City of Ryde Submission Stocklands 1-5 Khartoum Road Macquarie Park SSD Data Centre

SSD-63235720

**Submission Date: 28 March 2025
COR2025/146/1**

Figure 5: extract showing Council stormwater assets (Source: Ryde Maps)

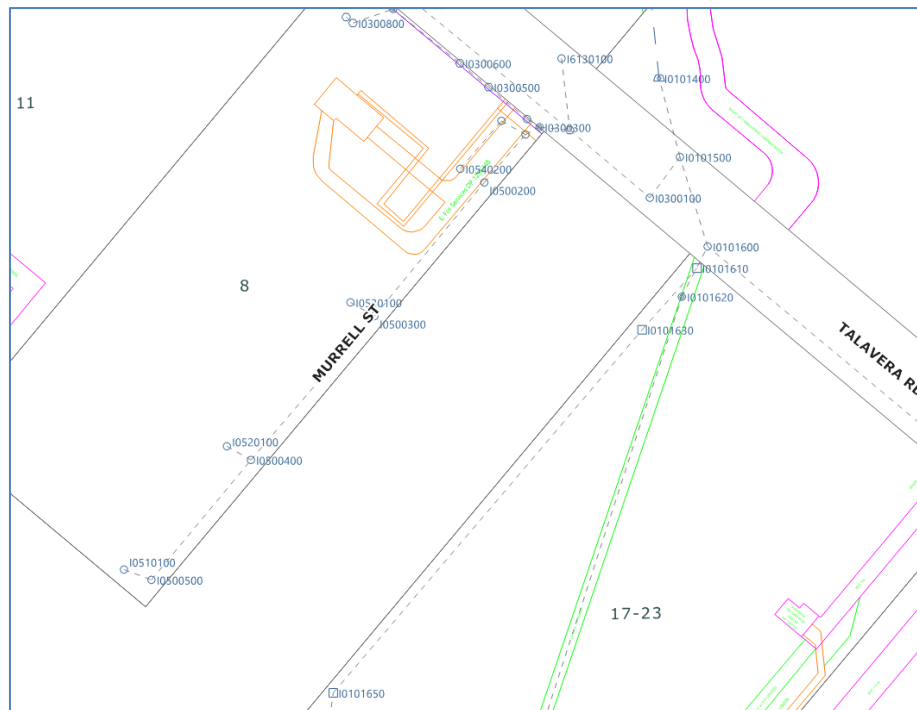
- Note above comments regarding flooding models to be provided
- To minimise the flooding impact within Talavera Road, the applicant will be required to upgrade the adjacent drainage network as shown in Figure 5 :

- Notably, the adjacent development at 17-23 Talavera Road has already upgraded the upstream drainage pipe. Without similar improvements, the proposed development may create a bottleneck in the area and adverse flooding conditions.

- Council will provide a detailed condition of consent requiring the above be completed.
- Drainage network capacity analysis must be demonstrated to ensure the proposed development can be effectively drained and managed via the downstream drainage network.

Figure 7: Section of Draft Architectural Plan (Source: Greenbox Architecture)

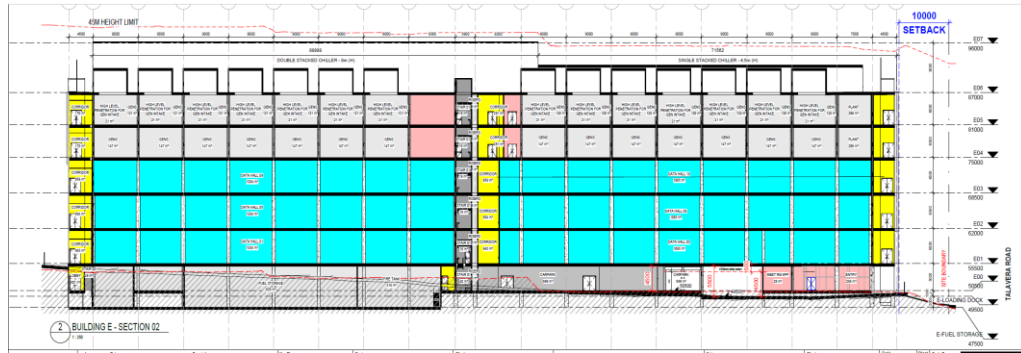
- Any cut and fill to be indicated in the flood model.
- Identify all proposed basement openings and/or other openings leading to the basement. Demonstrate these openings would not be inundated during PMF flood event (certified by a flood engineer)

Figure 10: Extract from Ground floor Plan (Source: Greenbox Architecture)

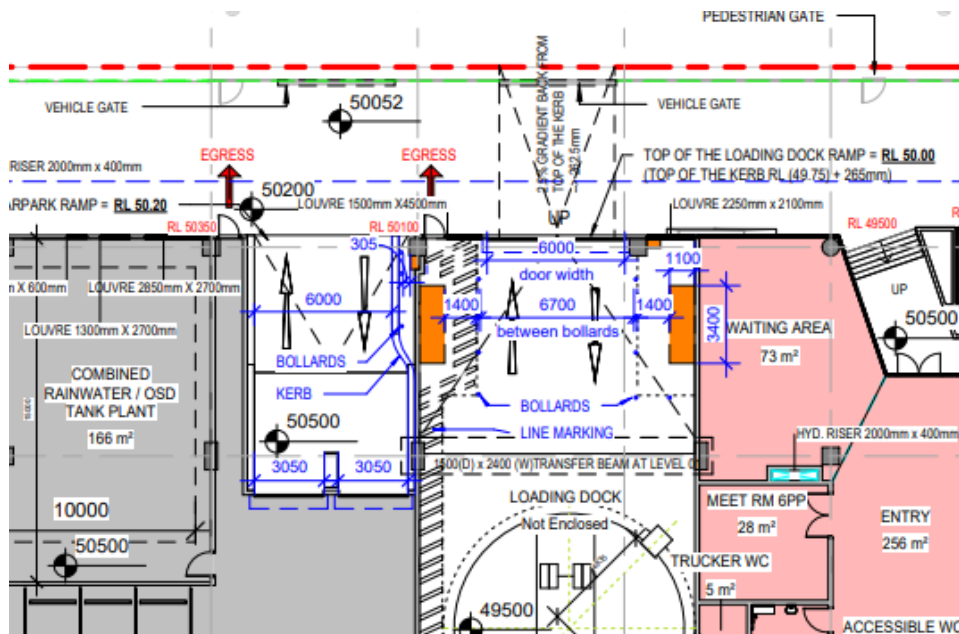
As outlined in Council's EIS submission, Council raised concerns with vehicle entry points which remain unaddressed. Council's advise stated:

- *Both vehicle entry points have a gate adjoining the road boundary alignment and therefore will result in vehicles having to stand on a public road waiting to enter the site. Any traffic control mechanism must be positioned such to accommodate the largest vehicle wholly off the public domain.*

This has not been addressed in the current EIS. To resolve the matter, Council has provided a

recommended condition of consent. Please refer to the Councils recommended conditions for conditions of consent, which will be provided separately to this submission.
